6.6 Consultation – NSW Government and Manly Council

Letters from NPWS concerning the proposals for modification of the CoPA – North Head Quarantine Station Conservation and Adaptive Re-use, and letter sent to Manly Council.

Mawland Quarantine Station Pty Ltd Application for Modification of Conditions of Approval for Q Station

QStation- S75W Modification Application-North Head Manly

Project No. 2-023
 Drawn by: * Name/Int PD
 Author: PD
 Date: July 2016
 Scale: As shown
 Drawing No. A02
 Issue: P2
 P of Date: 5/4/17

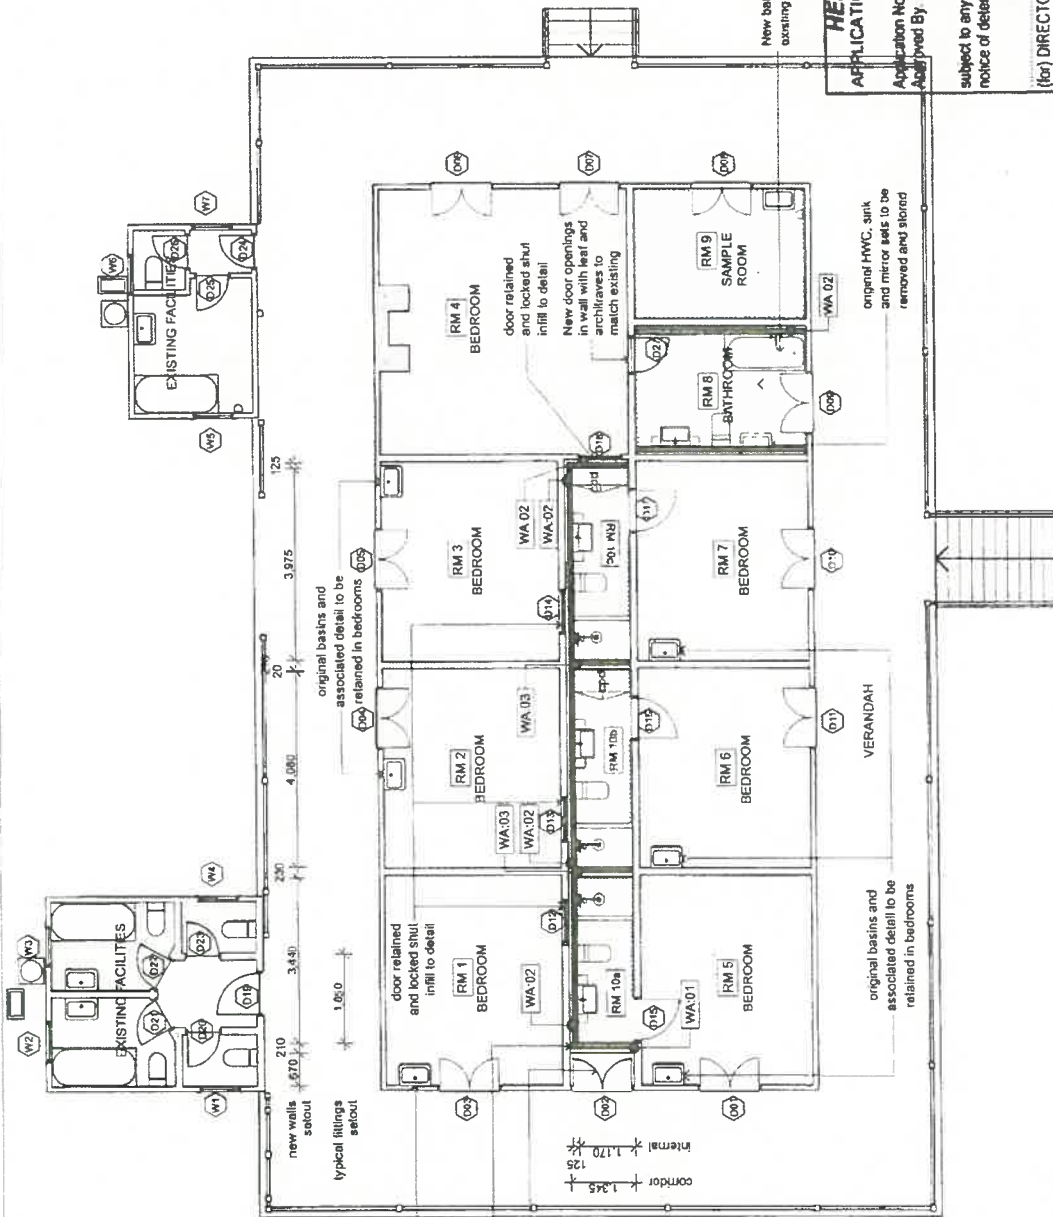
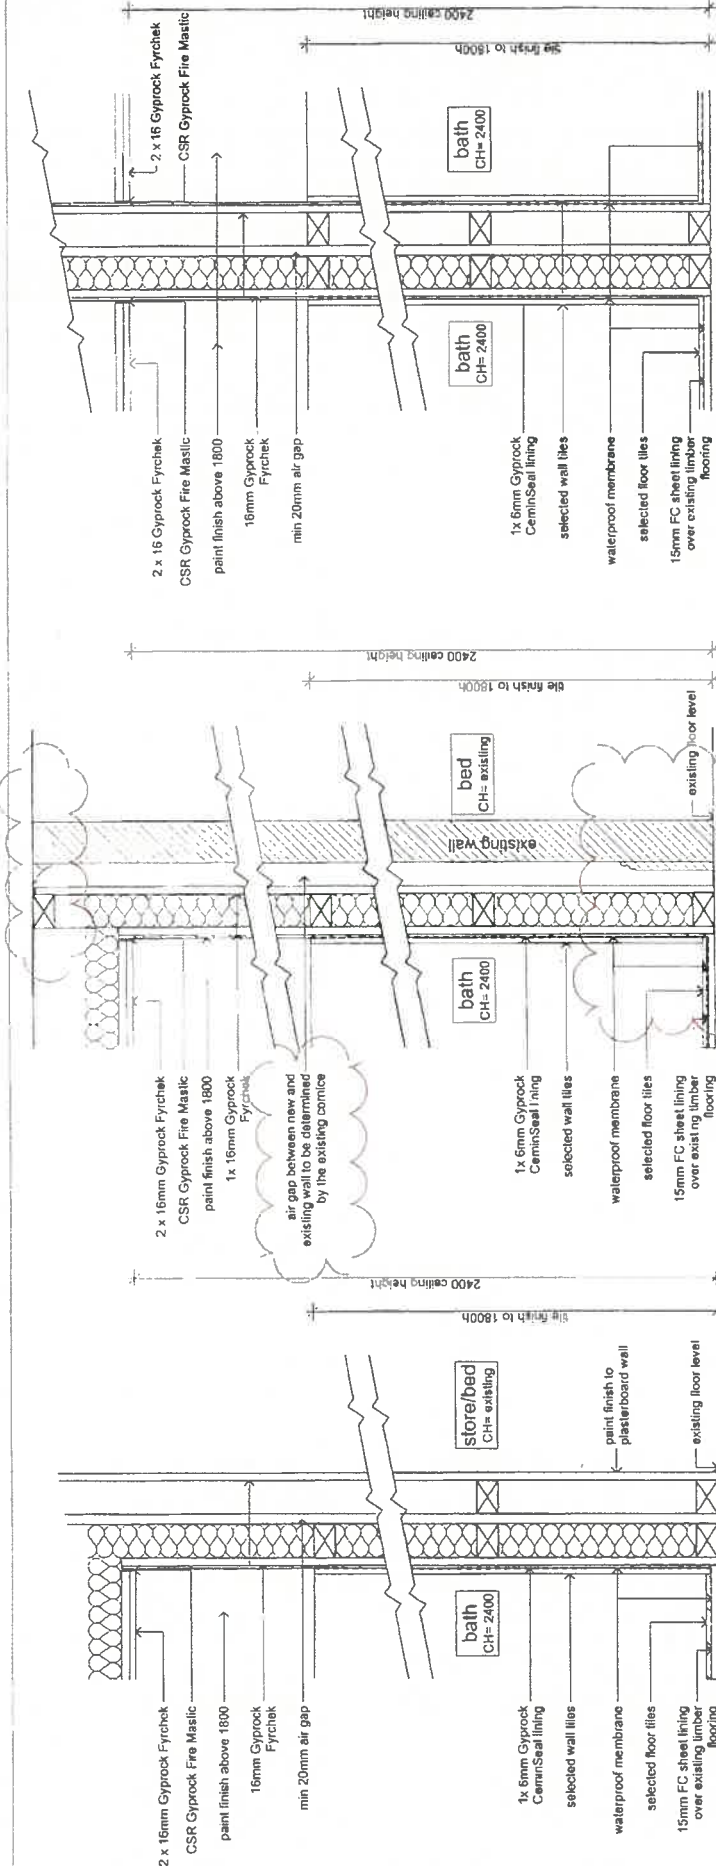
Layout of buildings P1, P2 and P9

The proposed changes involving the use of corridor space as bathrooms is supported in principle, provided that the integrity of the buildings is retained, significant elements of heritage fabric are protected and the overall balance of uses across the site is maintained.

However, NPWS is concerned that the wording of the proposed change to condition 21 is not clearly expressed and requires clarification.
